Please ask for: Ms Iqraa Malik
Email: iqraa.malik@terraquest.co.uk
Telephone: 01212341390
Our Ref: R/150/21/HH
Your Ref:
Date: 22nd June 2021

Application for Planning Permission for Works or Extension to a Dwelling

Development: Erection of side/rear extension following the demolition of existing rear extension
Location: 7 Milton Close Rustington BN16 2PN

Block Plan
(Scale 1:500)

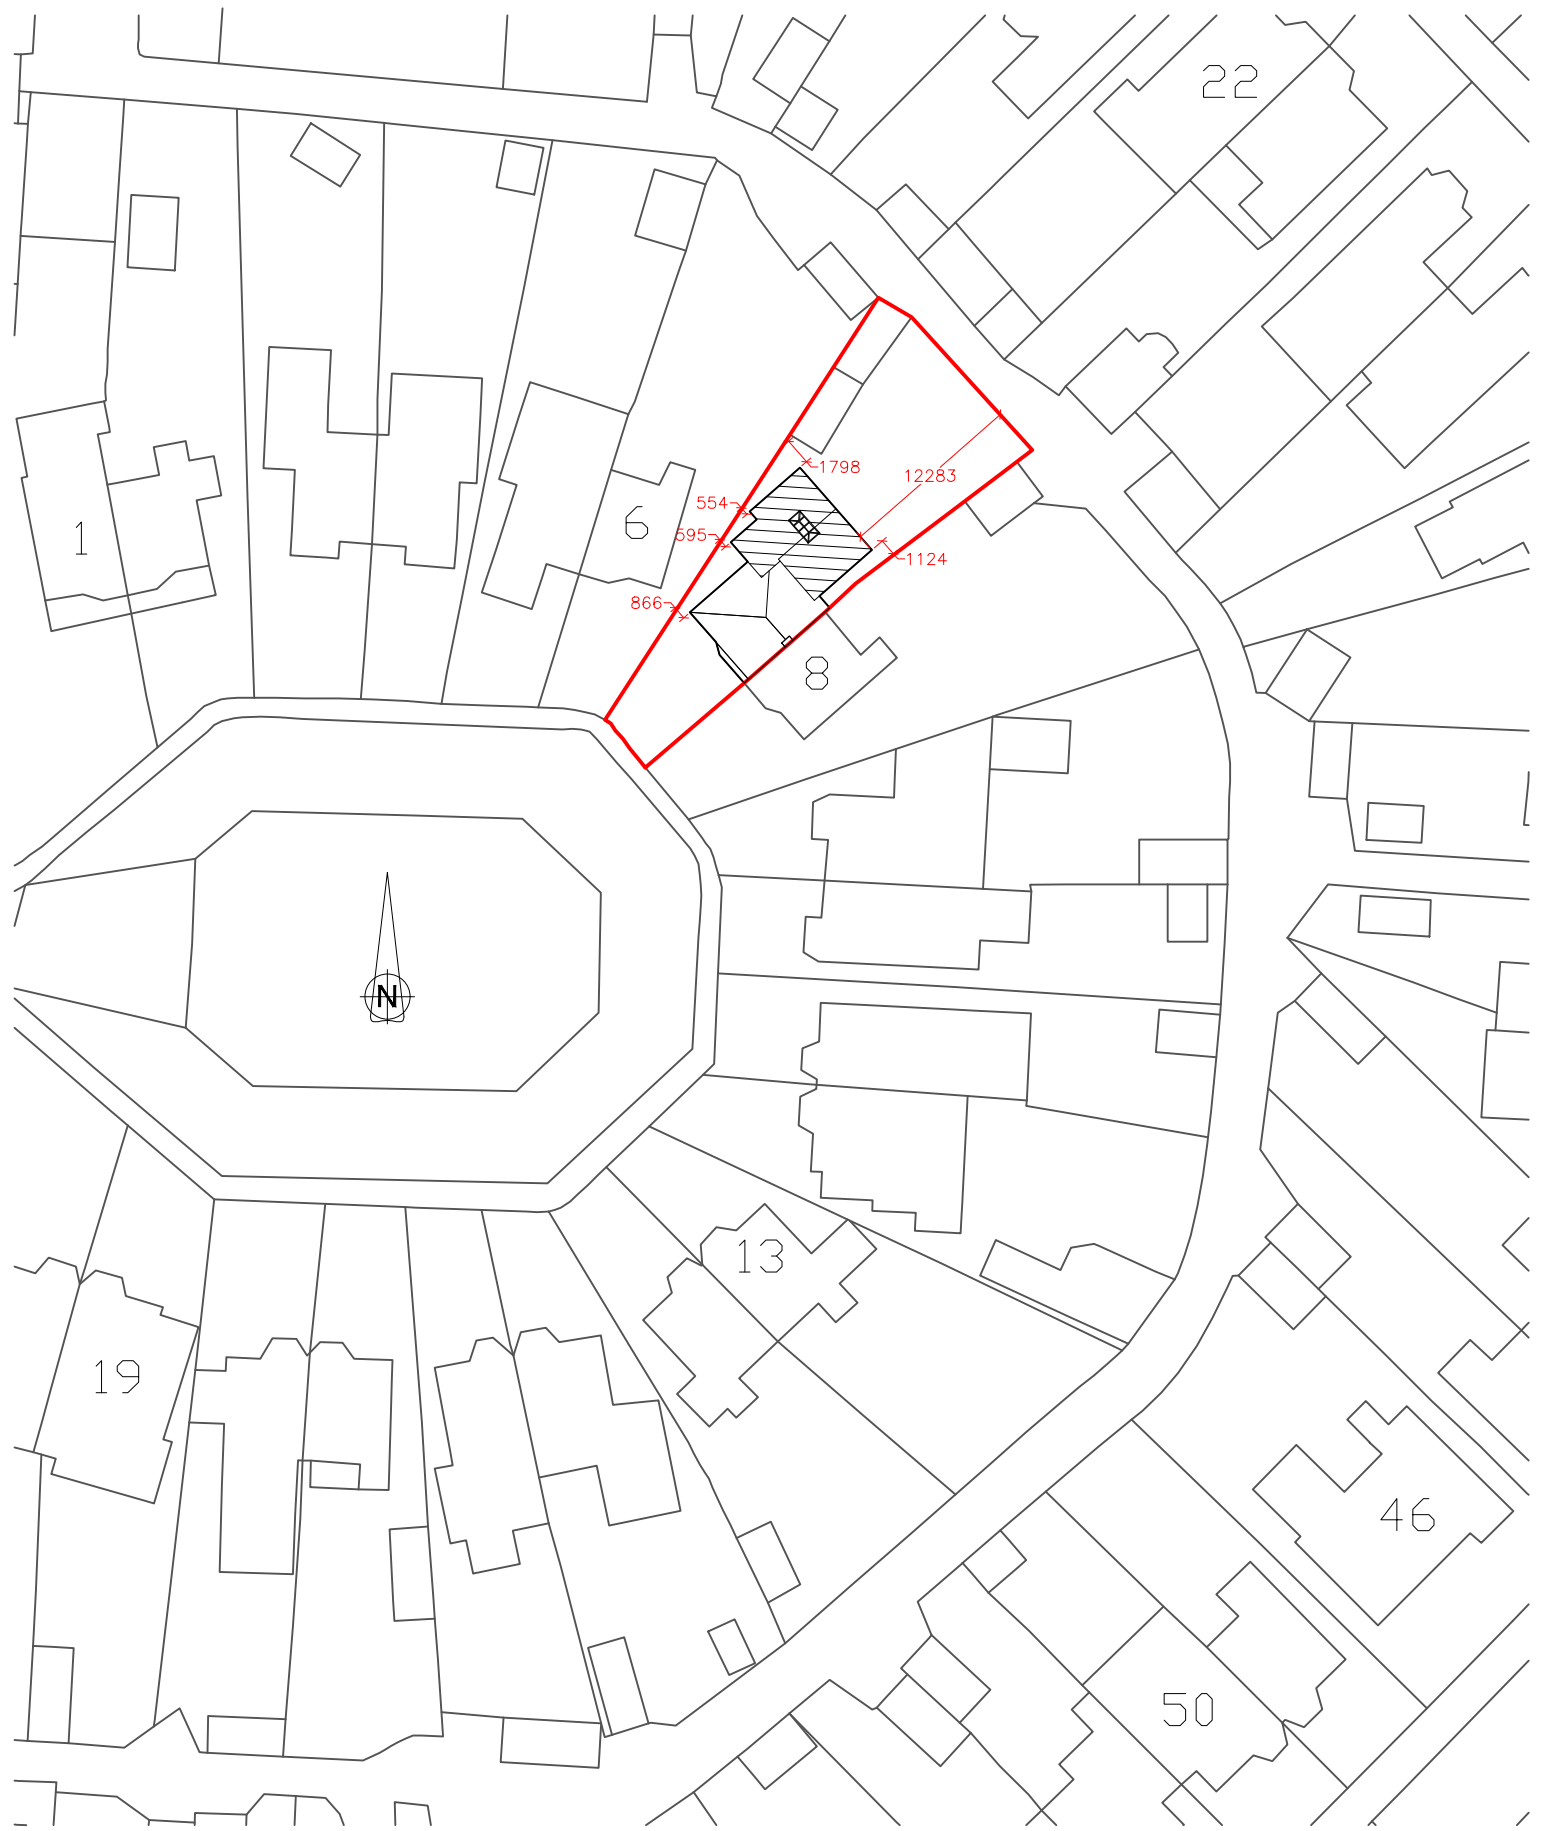
You are required to have dimensions from the proposed extension(s) to all site boundaries. Please amend.
